From: Simon Davis
Sent: 24 February 2020 11:04
To: [REDACTED]
Subject: FW: BE/109/19/OUT - Land East of Shripney Road

Please see below comments on the Sequential Assessment. Could you consider and respond to me please.

Figure 2: Map showing HELAA (2018) sites within agreed locational area superimposed on EA Flood Map for Planning

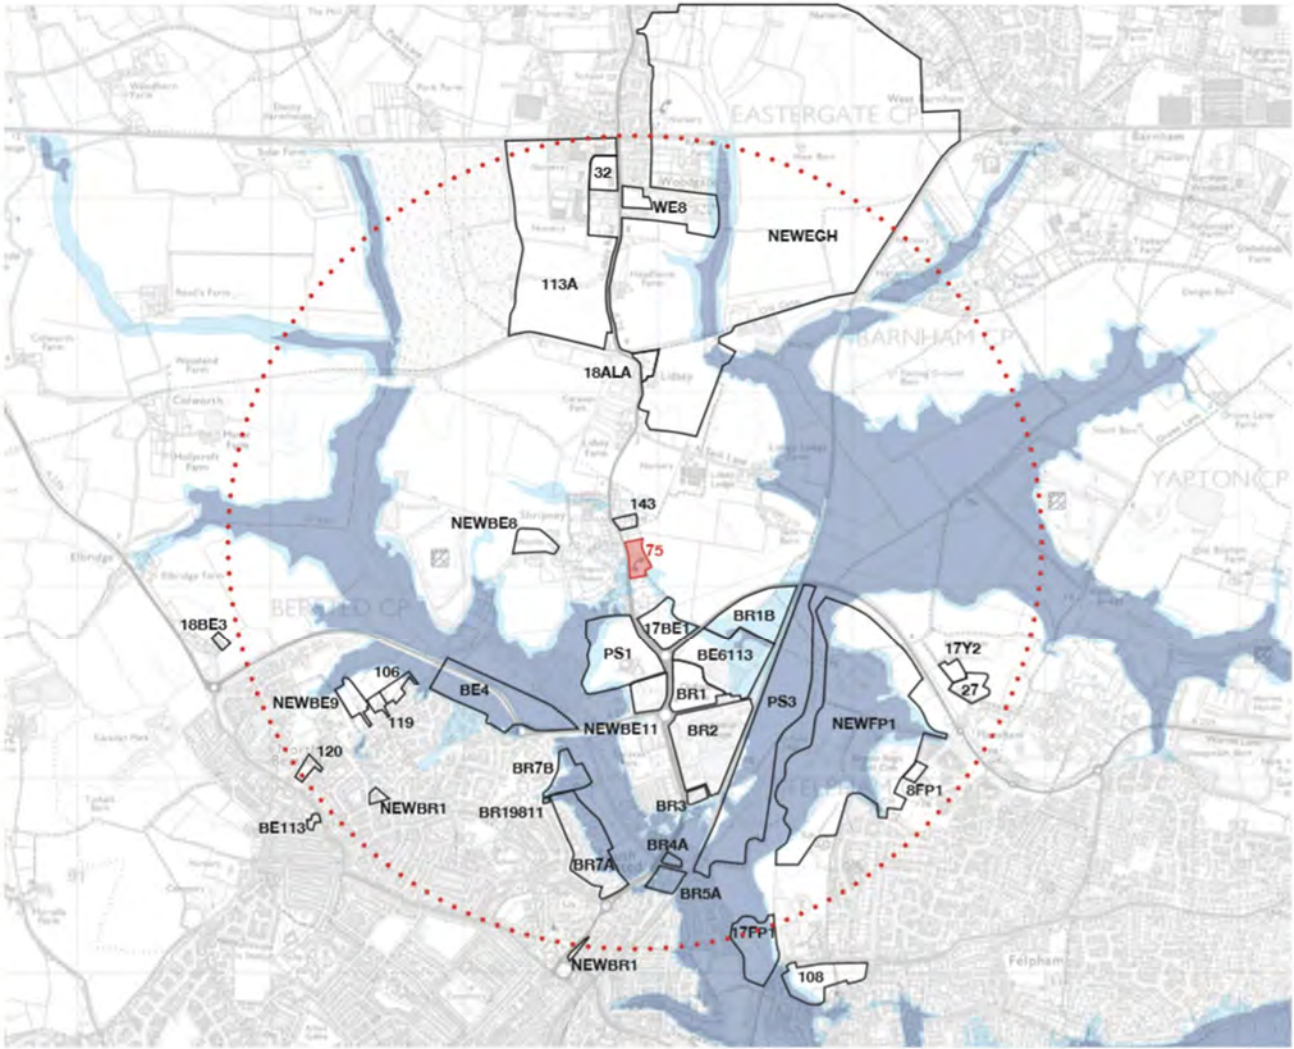
1. 18FP1 – this has permission and through planning process so should have been excluded

2. I am unsure about 18AL4 and WE6, as although there are obvious differences in terms of site size and capacities they are allocated for housing (not alternate use) in ALP and from flood perspective lower risk. Have a read of Information about alternative sites on this [page](#). I could see they could be discounted for other reasons
3. I will accept that WE8 and 32 could be considered reasonable from flood perspective but 32 should have been excluded on the basis of the fact that this has permission through the planning process

Unfortunately cannot agree with their final conclusion that the sequential test has been passed purely as there are no other available sites on basis of the current information, as they have not really provided answer in terms of the two sites mentioned under 2 above. I suspect that this is really a planning issue
